DECISION DELEGATED TO DEVELOPMENT MANAGER

Application No: H16-0342-19 **Applicant:** Mr Karl Frith
Proposal: Proposed attached indoor swimming pool, changing rooms and plant room
Location: Heatherdown Elm Lane Spalding
Terminal Date: 23rd May 2019

Title
PROPOSED ELEVATIONS (Sheet 1 of 2)

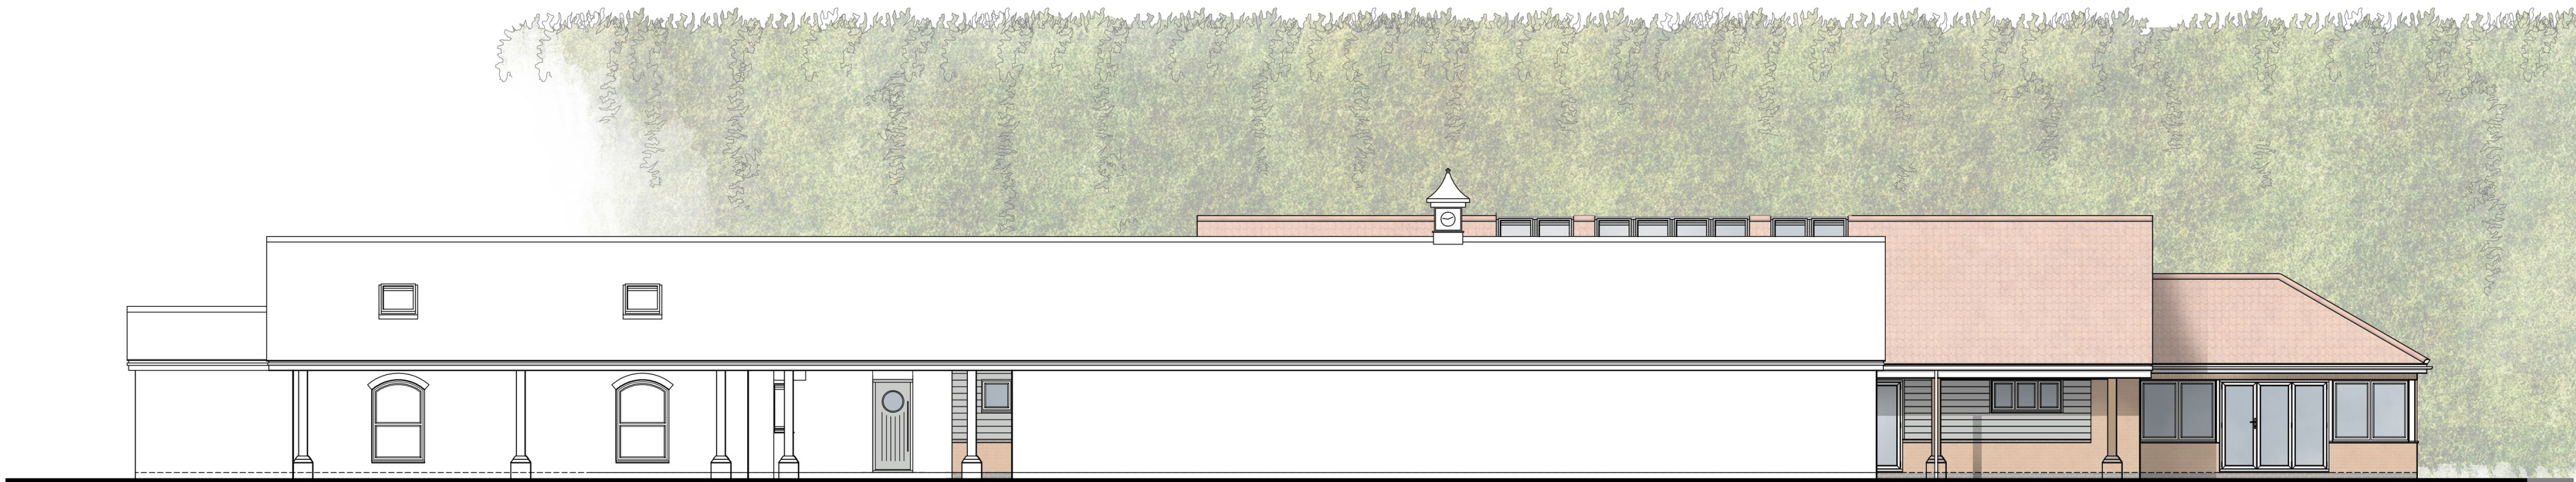
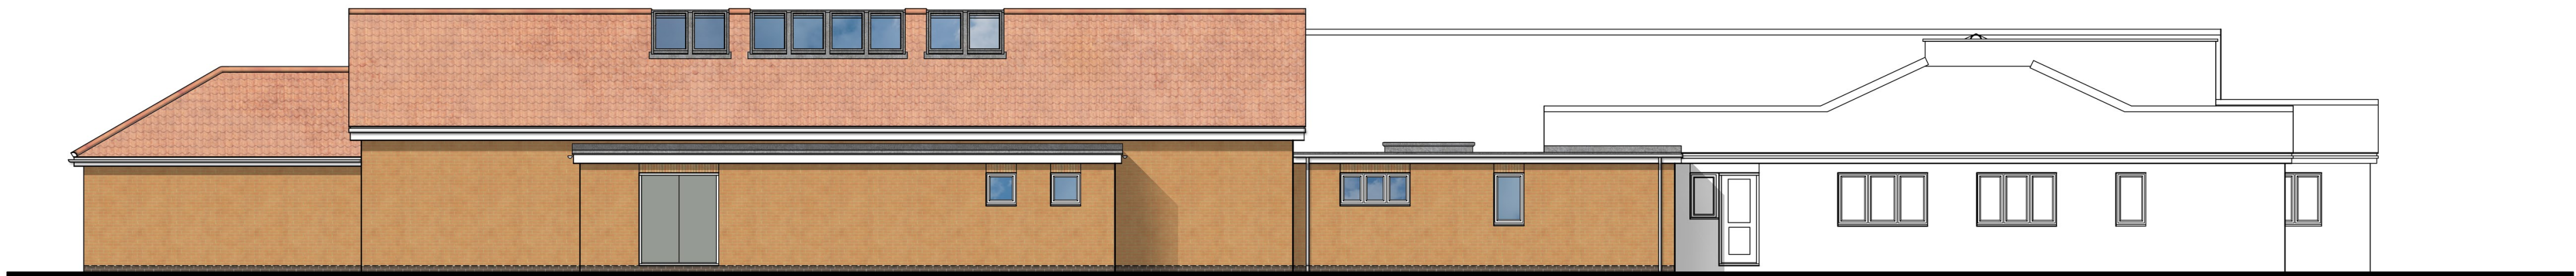
The proposed development would constitute a large extension of the dwelling. It would project approximately 32 metres from the eastern part of the building to north. It would measure 11.50 metres in width and 6 metres in height, both as maximum dimensions. Having regard to the measures of the house, the extension would be subservient to the host property in terms of scale, massing and bulking.

Whereas the plant room at the rear of the pool would have a flat roof and the sun room a hipped roof, the entire swimming pool would be covered by a gable roof. Such combination of roof styles matches well with the remainder of the building which has already an eclectic roof layout. The ridgeline of the swimming pool gable roof would be set marginally higher than any roof pitch on the building. However, this is not considered to be visually incongruous to the entire dwelling.

The form of development would substantially alter the house footprint to create a U shaped building with an enclosed courtyard. This layout would be more reflective of the rural setting where the property is based. A porch along the western elevation would replicate that existing on the opposite elevation.

Title
PROPOSED FLOOR PLAN

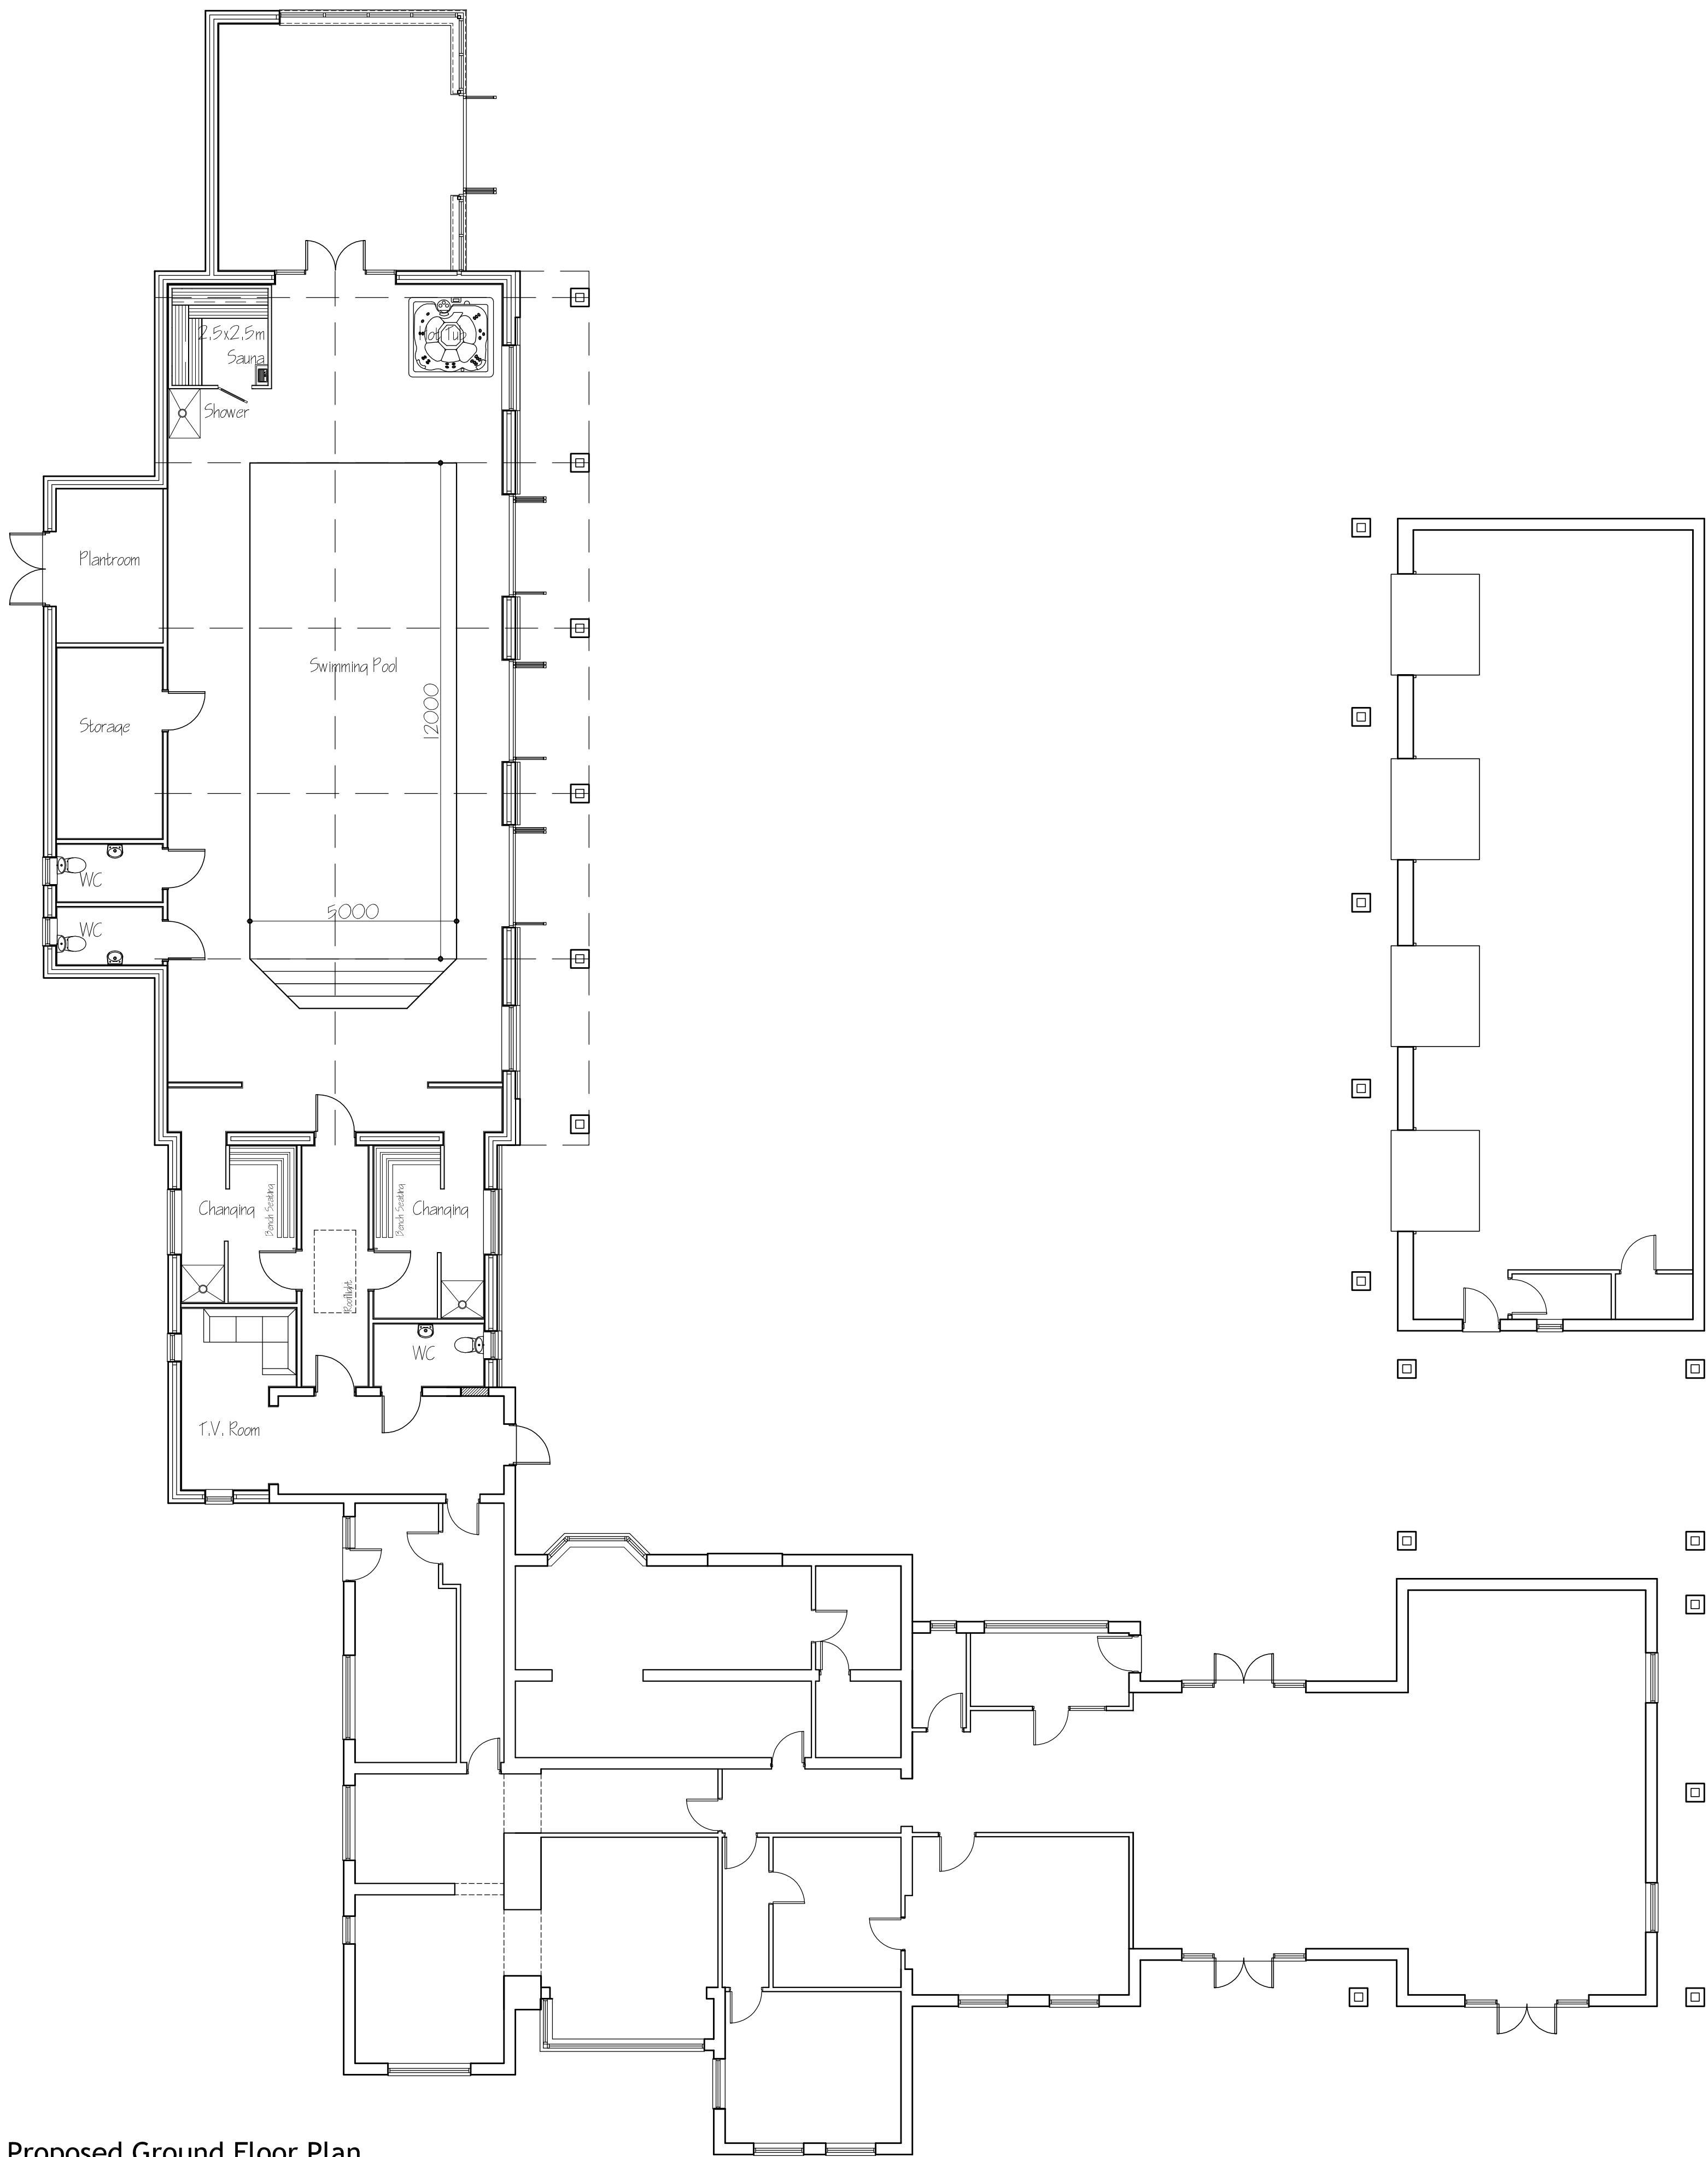
The floor layout plans shows that the purpose of the development is to accommodate a swimming pool, changing rooms and a plant room. The purpose of the proposal would be acceptable given the residential use of the building.

The changing rooms would be on the sides of an aisle that connects the house with the swimming pool. Externally, they would form a single-storey flat roofed link that would remarks the subservience of the intended development and its ancillary use to the dwelling.

Title
PROPOSED SITE LAYOUT

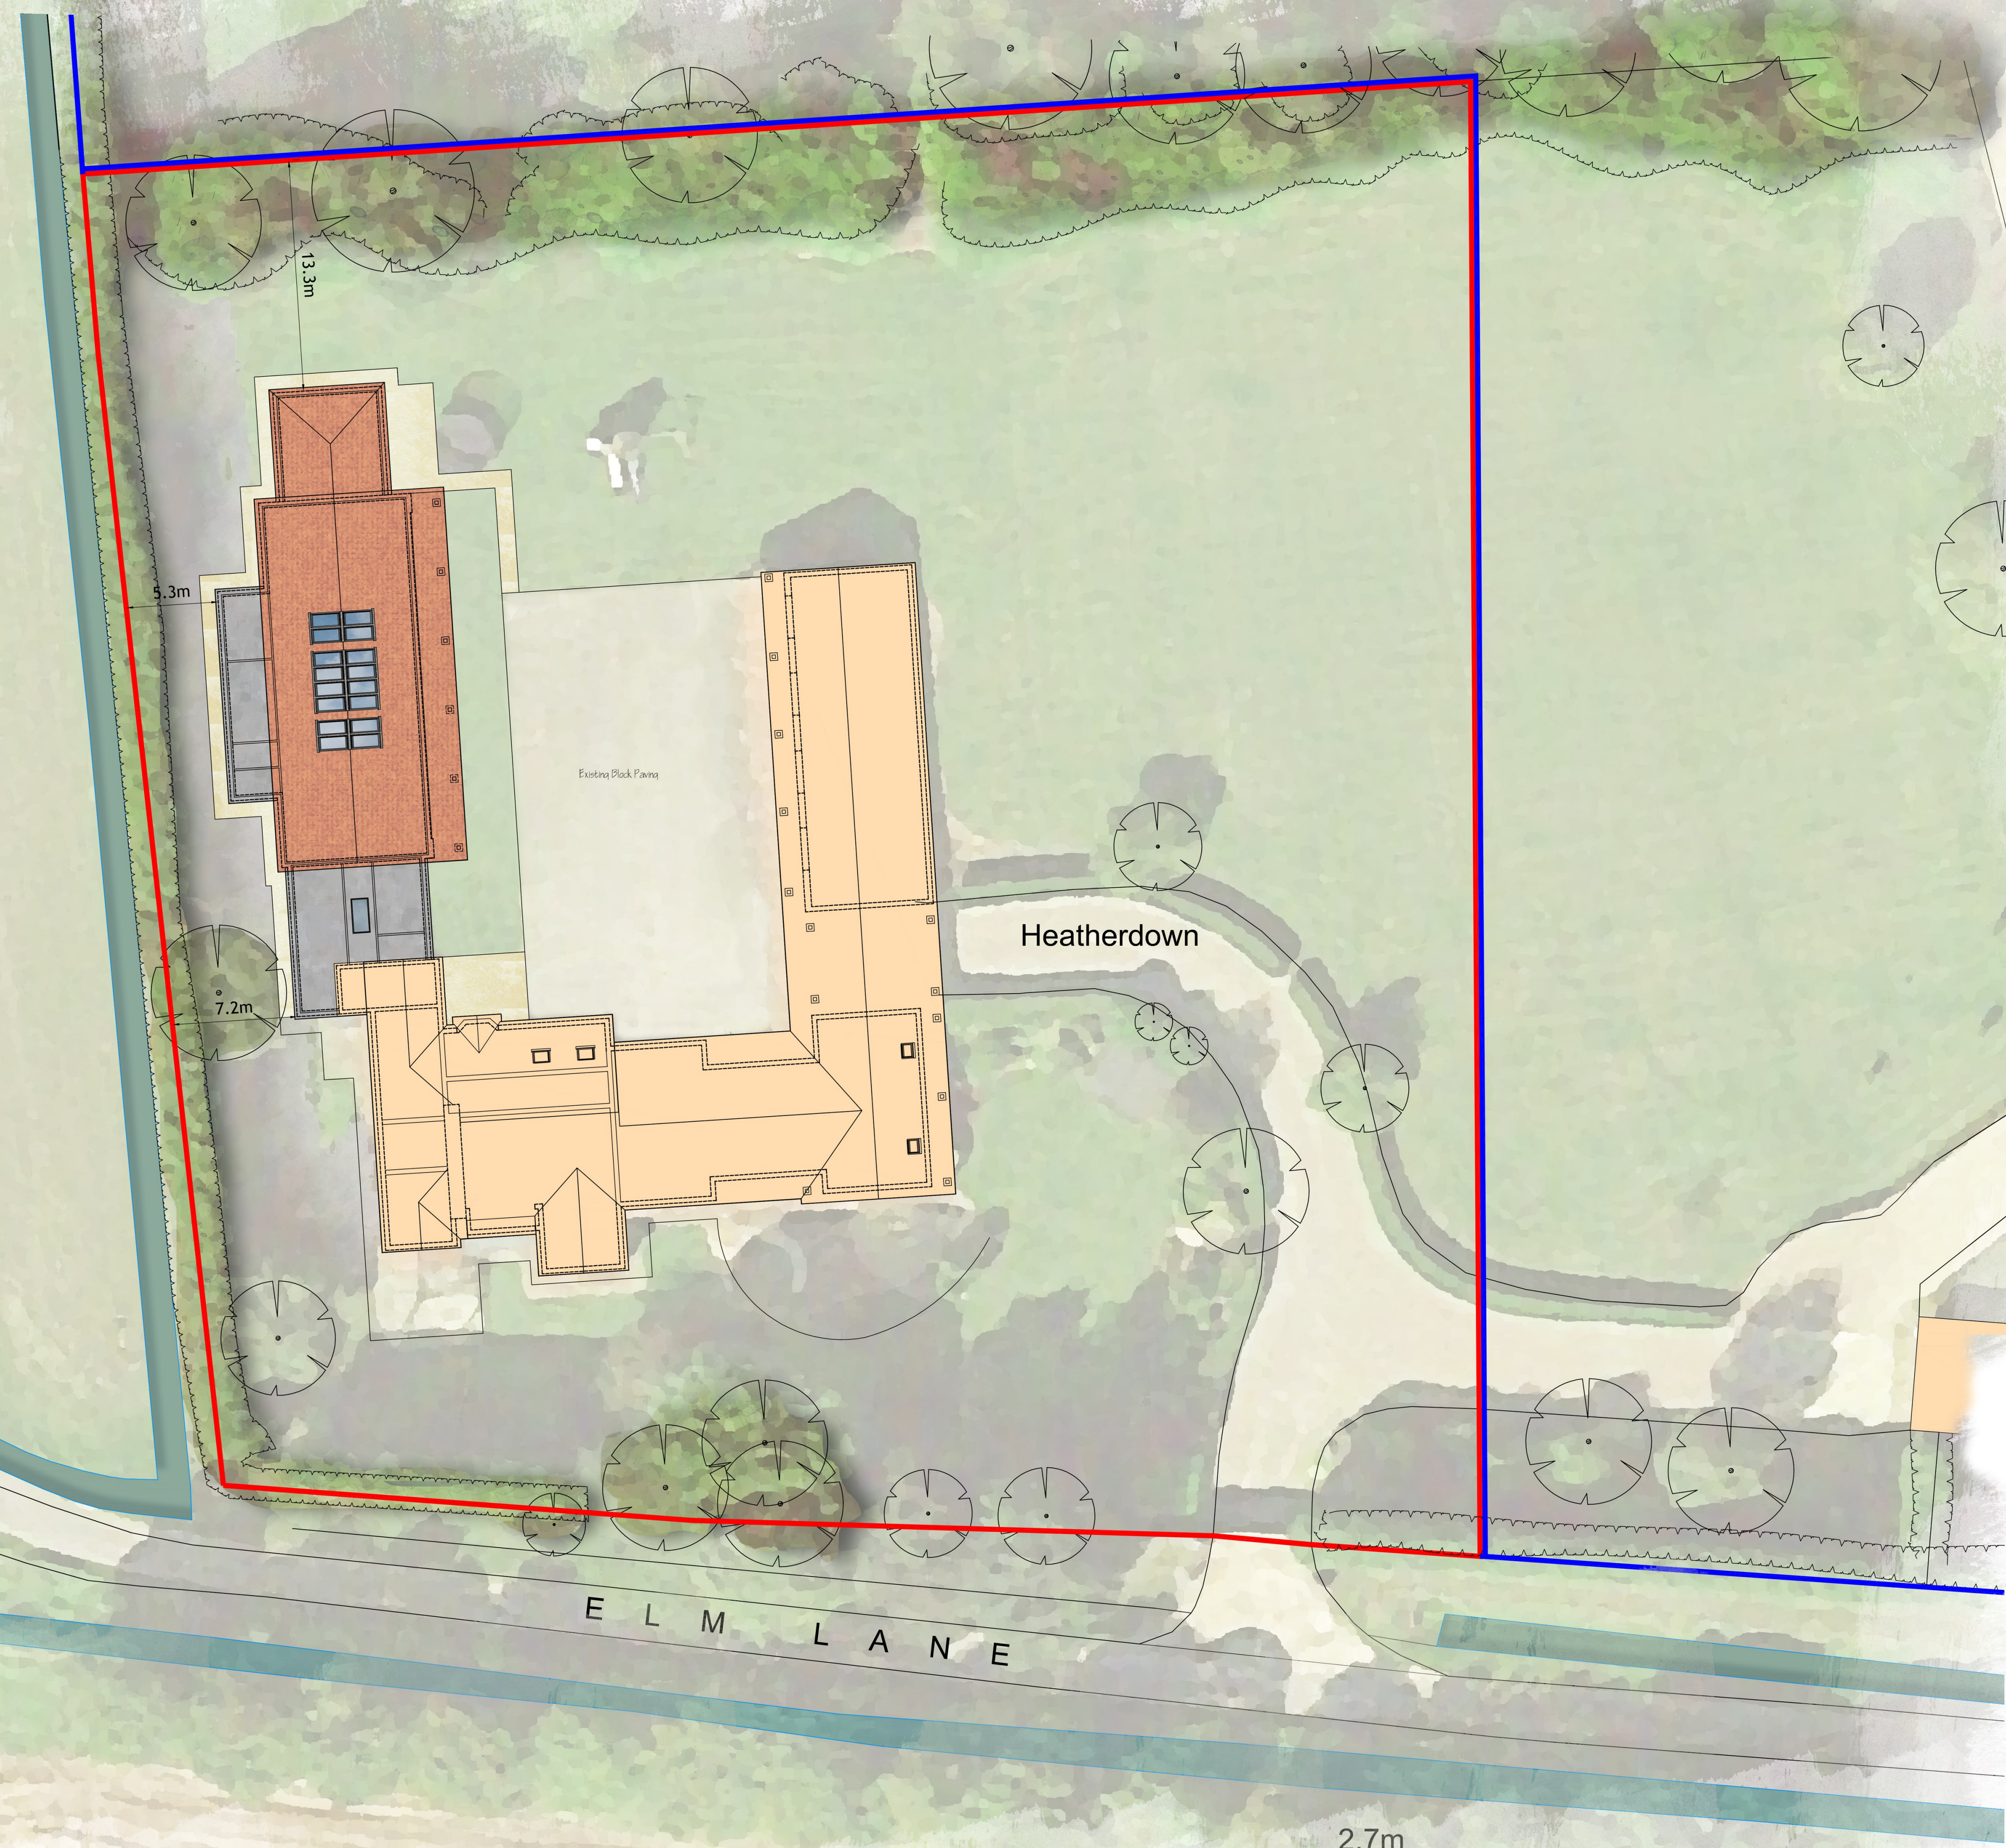
A more than 2 metre hedgerow is on the eastern and northern boundaries. The proposed large extension would not be perceived from the adjacent land. In any event, the development would not create any harm to residential amenity. There is a long separation distance with the opposite wing of the house and the nearest neighbouring property Heatherdown is 200 metres away.
